04/03/2022

**St John of God Richmond Hospital Redevelopment (SSD-10394)  
Request for additional information**

Figure 1: Height plane diagram looking east

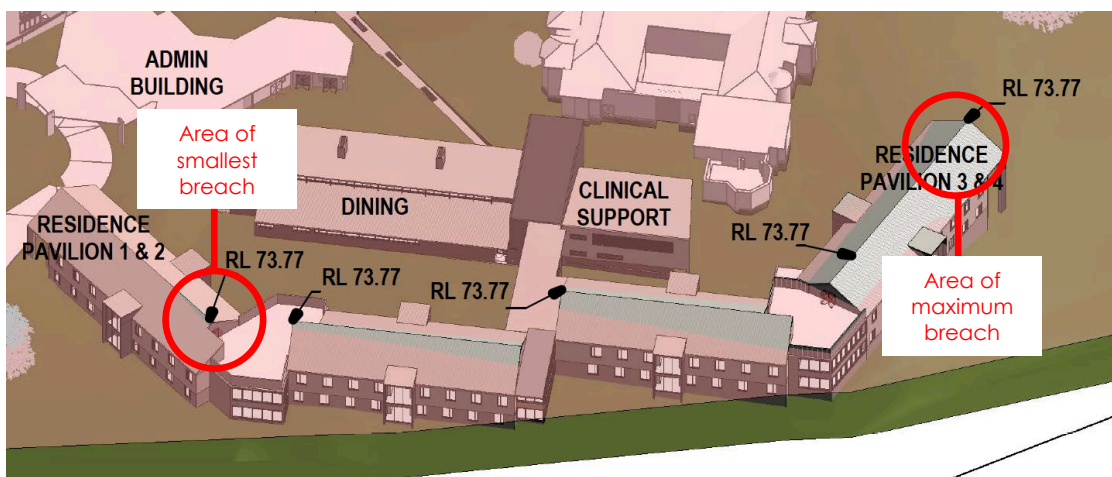
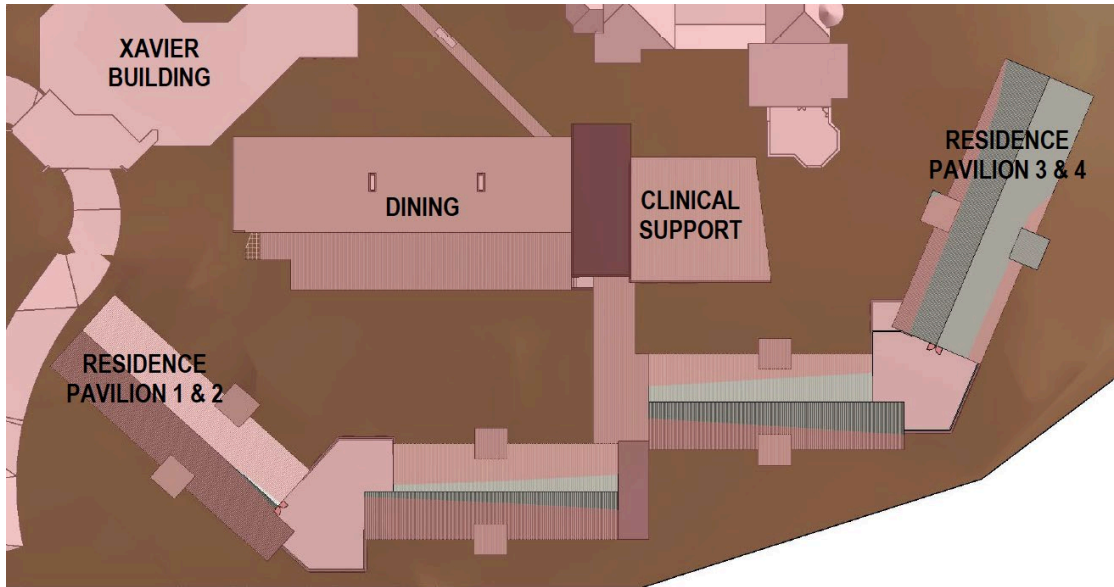
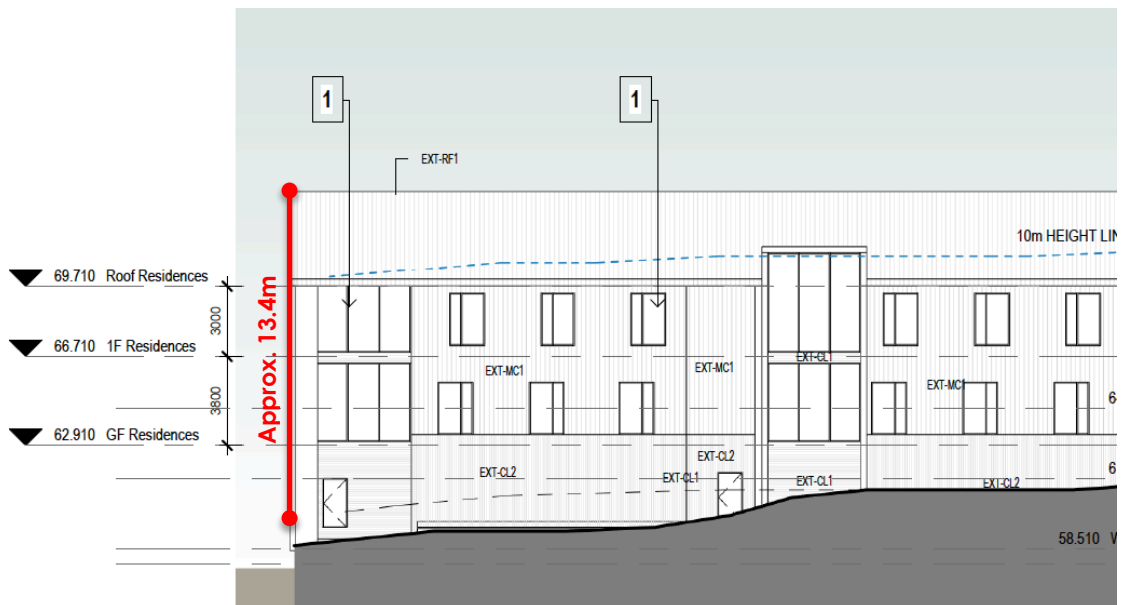
- clarify the number of full-time equivalent construction jobs generated by the project.
- provide a cover letter prepared by a qualified specialist, correcting the original BDAR by clarifying:
  - the tree species within the Shale sandstone transition forest TEC being sought for removal – currently a Forest Red Gum is listed within the BDAR for removal but is not listed on the most recent tree removal plans provided.
  - the BDAR does not note the removal of a narrow-leaved ironbark, which is identified on the tree removal plans. Please clarify.
- provide the height exceedances of Pavilions 2 and 3 in metres – no updated Clause 4.6 necessary.
